Re: Planning Application number [2020/91215](#). Outline application for the erection of residential development Land at, Green Acres Close, Emley, Huddersfield, HD8 9RA

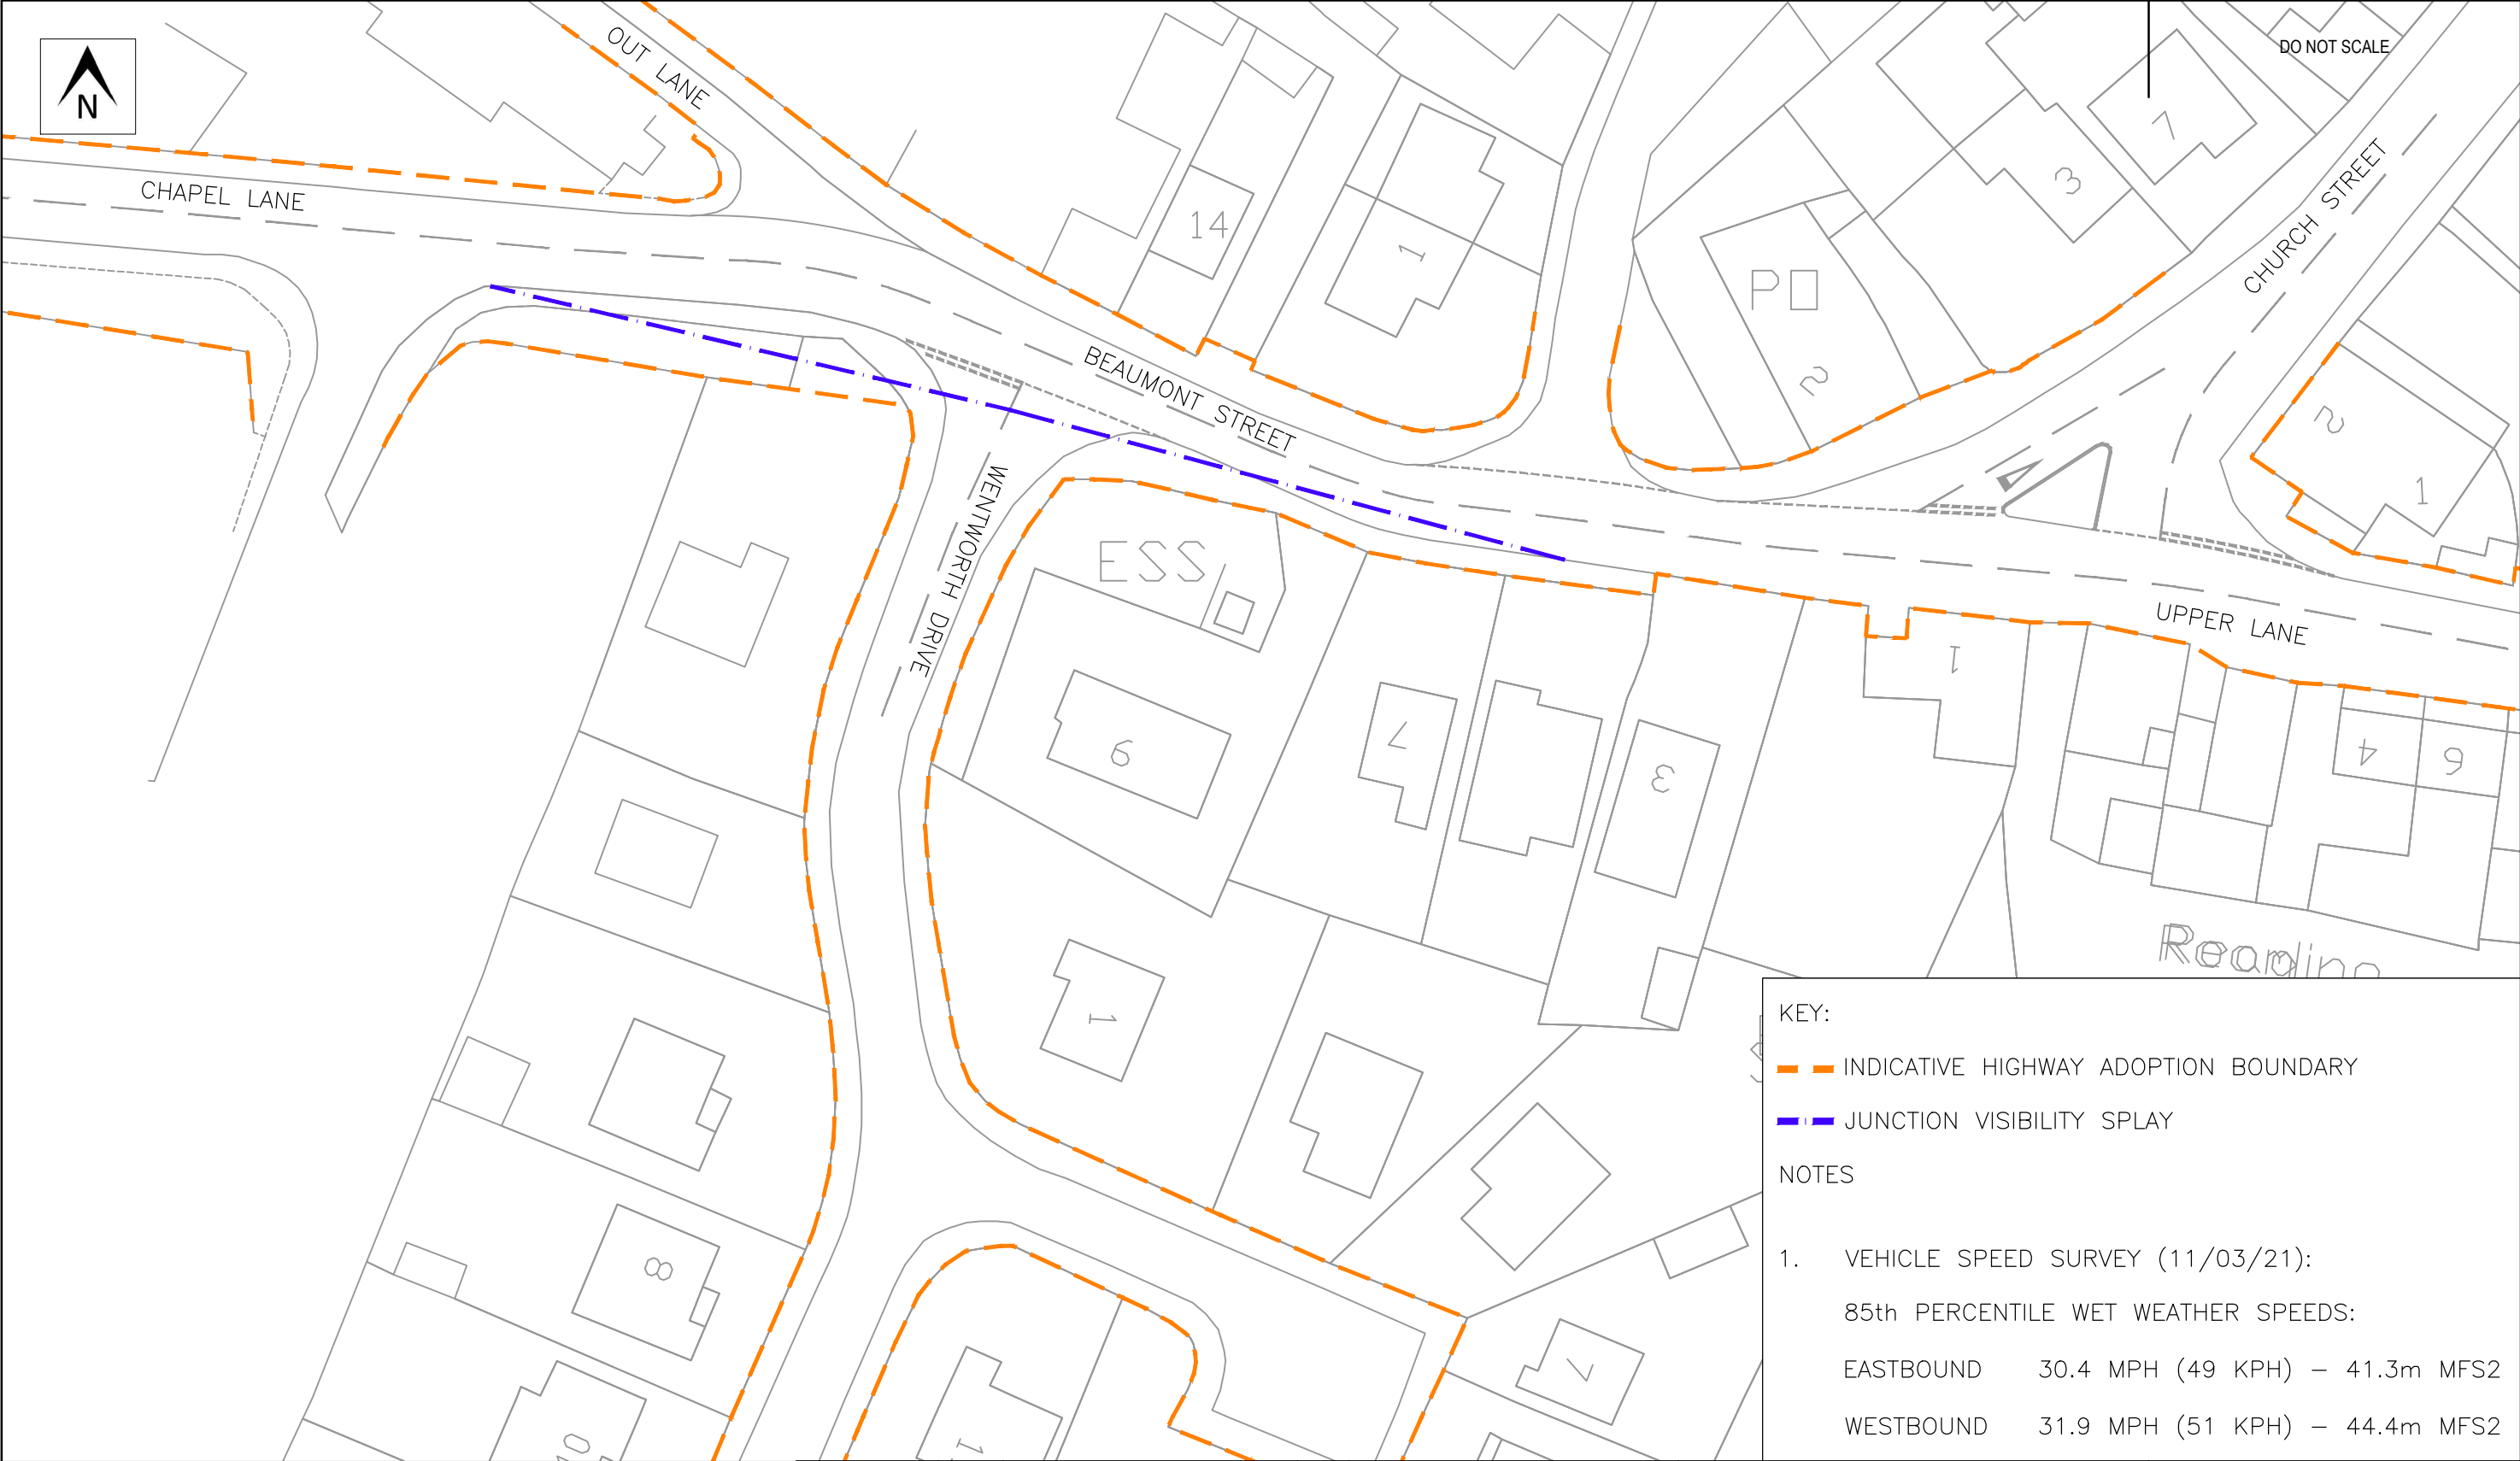
Concerning the new access point, I worry about access, particularly Wentworth Drive and the junction with Beaumont Street.

I am concerned that the applicant has not given due consideration to the re-sited bus stop, which adds to visibility problems exiting Wentworth Drive, due to people queueing for bus services.

At the junction of Wentworth Drive and Beaumont Street, vehicles travelling along Beaumont Street westbound, frequently have to manoeuvre their car into the entrance of Wentworth Drive, to avoid the traffic coming the other way. For those vehicles that are travelling east and approaching a blind rise, they often have to cross onto the other side of the road due to the parked cars on the side opposite the entrance to Wentworth Drive. This would be a problem in itself if it were just cars. However, matters are made worse because HGV's, double-decker buses and large agricultural vehicles often use the route.
